Application No: 22/505852/SUB

Location: Land Off Staple Street Hernhill Kent ME13 9HY

Proposal: Submission of Details Pursuant to condition 14 (Surface Water Drainage Scheme) of Application 20/503666/FULL.

Thank you for your consultation on the above referenced planning application. Kent County Council as Lead Local Flood Authority have reviewed the latest correspondence from Sweco (2 August 2023) and have the additional comments below:

Drawing Title: **PROPOSED DRAINAGE LAYOUT SHEET 2**

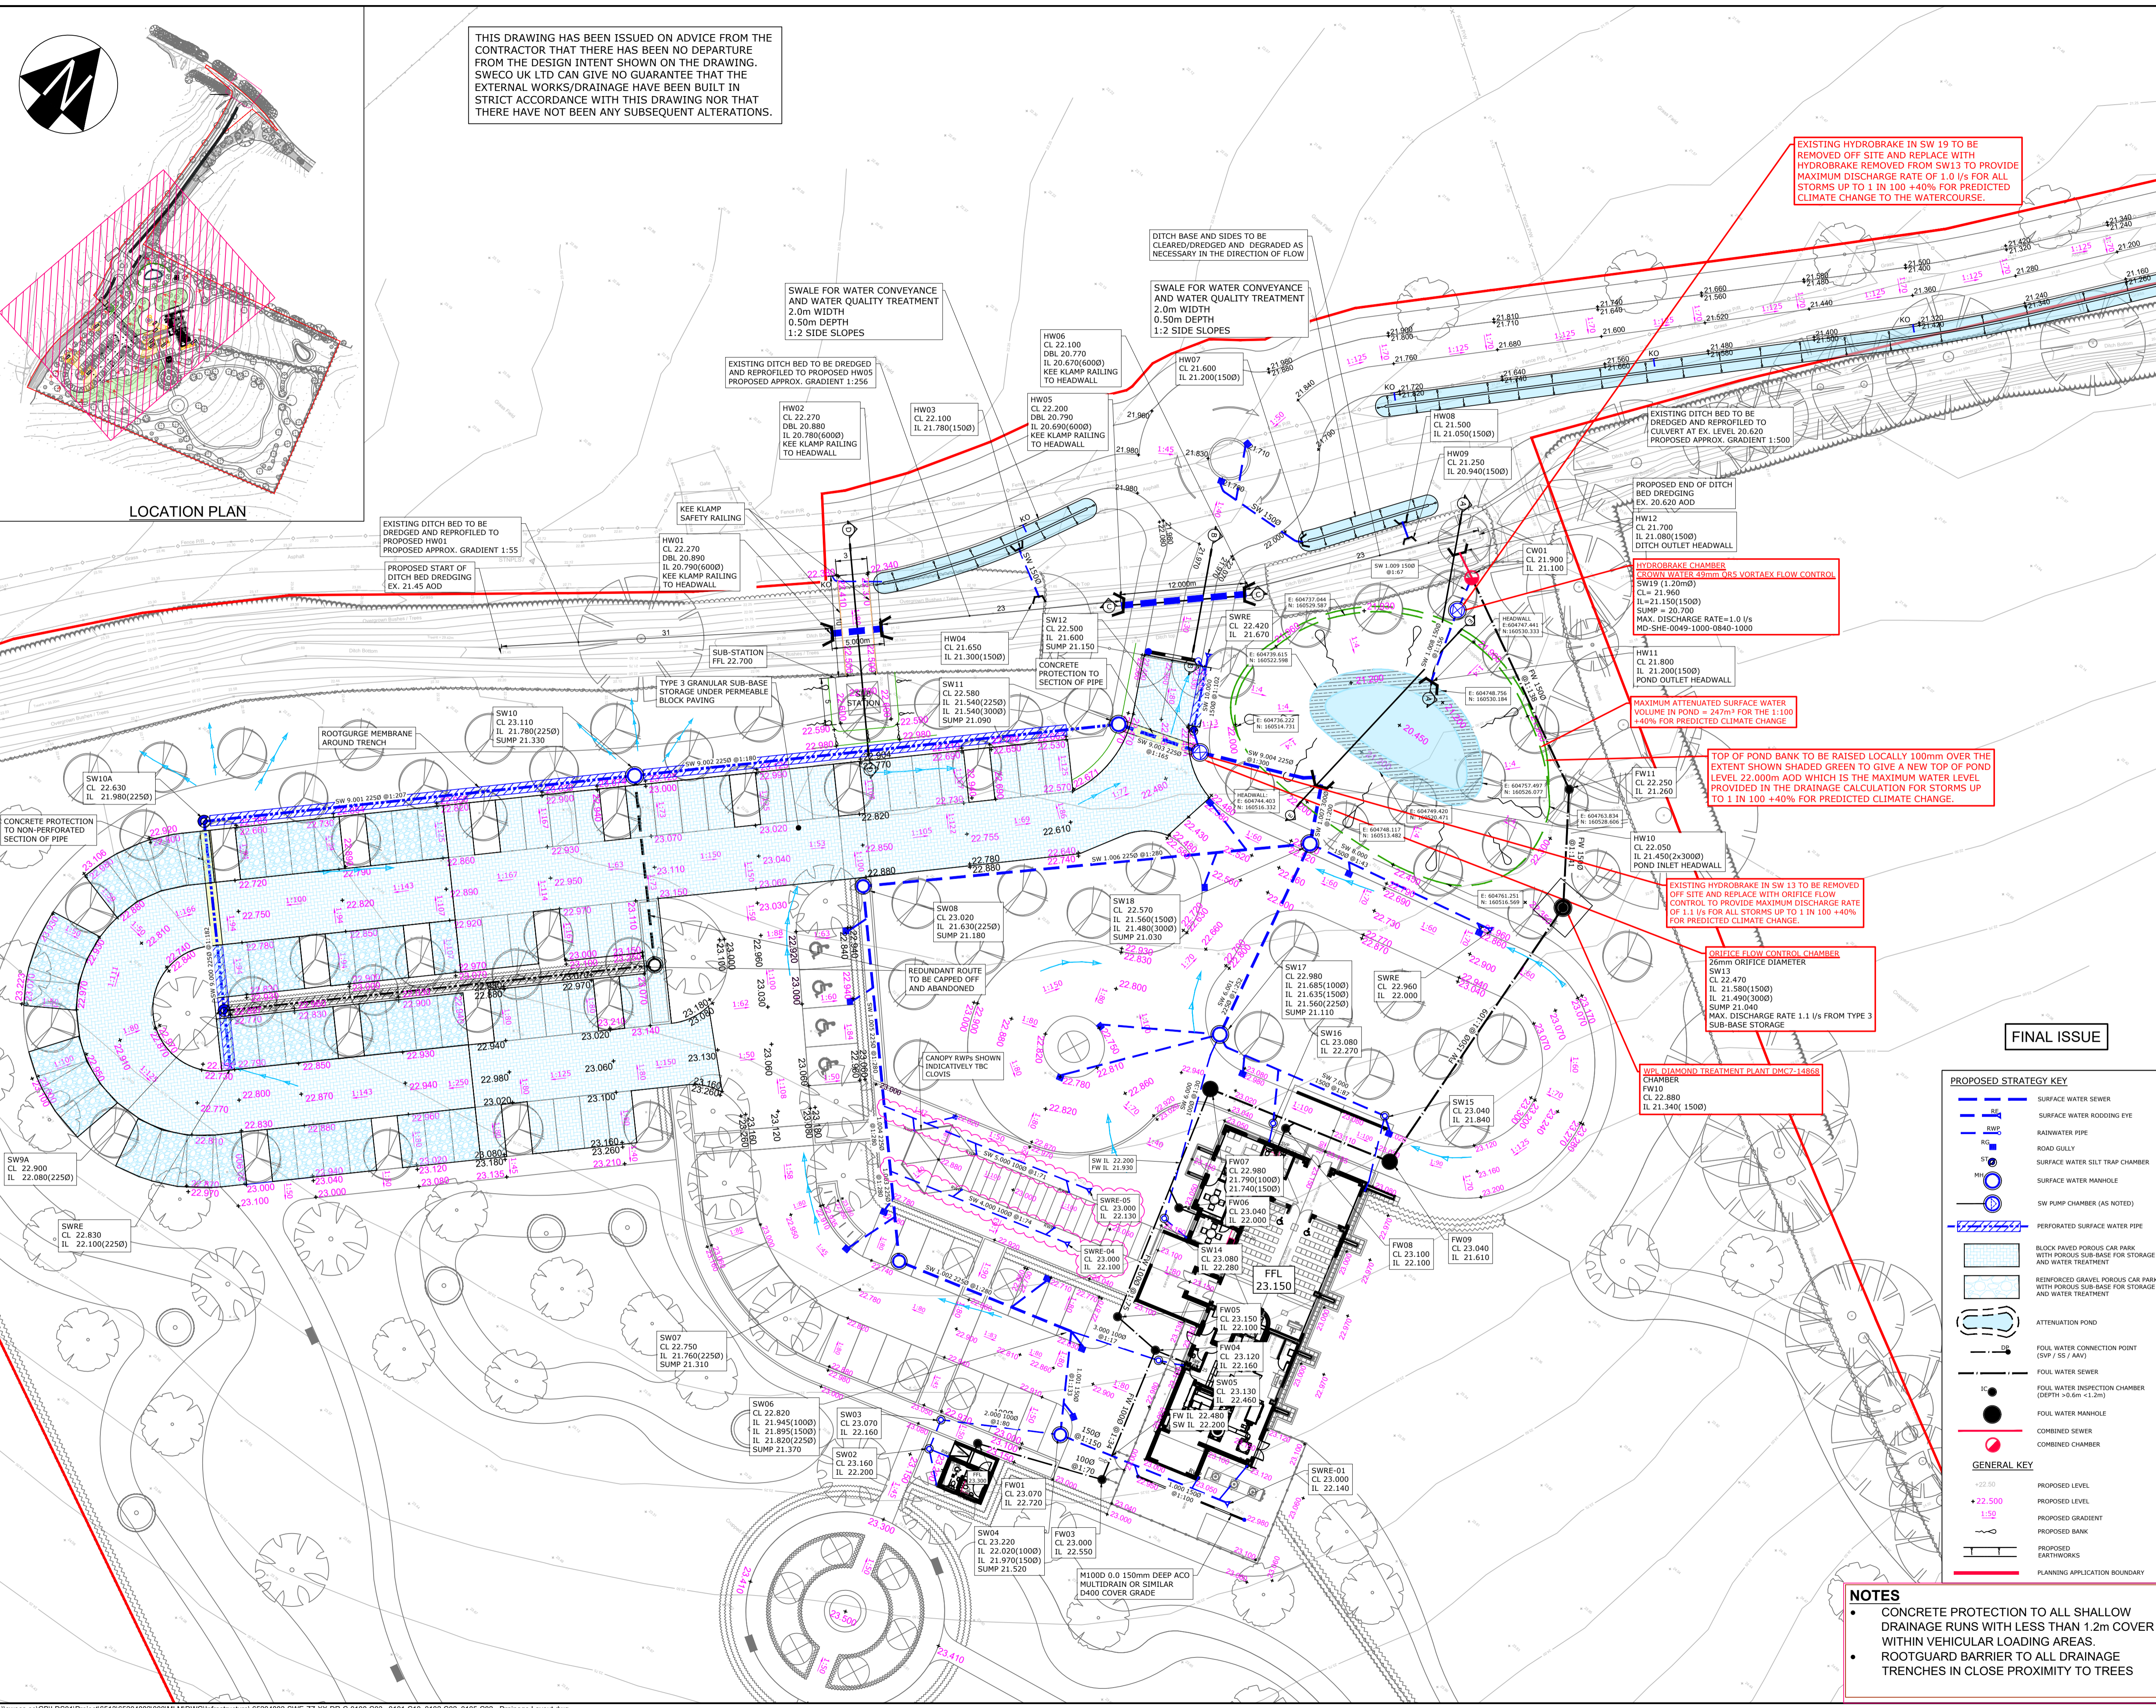
1. Whilst not raised within our previous consultation responses, we are note from Statement 2.4 of the Flood Risk Assessment provided as part of the full application (20/503666/FULL), that the outlet for the northern pond/watercourse passes under Staple Street and connects into the wider field ditch network. A subsequent review indicates that this connection to the wider network would likely be through the existence of a land drain and not an open watercourse feature as alluded to within the FRA. With the entrance of the site and pond being the low point, there have been resident comments highlighting this as a problematic area for flooding of the highway. In view of this, we have concerns as to the current condition/operation of this land drain.

In light of these concerns, we would request that a CCTV investigation is undertaken of the network downstream of the pond to ascertain its current condition. A failure/blockage of the land drain could be responsible for this periodic flooding to the junction and pond raised by resident comments. With the additional volume of surface water from the new development and on going discussions around the runoff rates from, there is therefore a rightful concern that this flooding could be increased if there is an existing problem with this drain.

3. From residents comments and supporting photographs, we are aware that an additional pipe connection has been made to the existing pond next to the access road (near to headwall serving swale outfall). The LLFA envisage that this pipe extends under the road junction to Staple Street however, we would request further clarification as to its purpose and route.
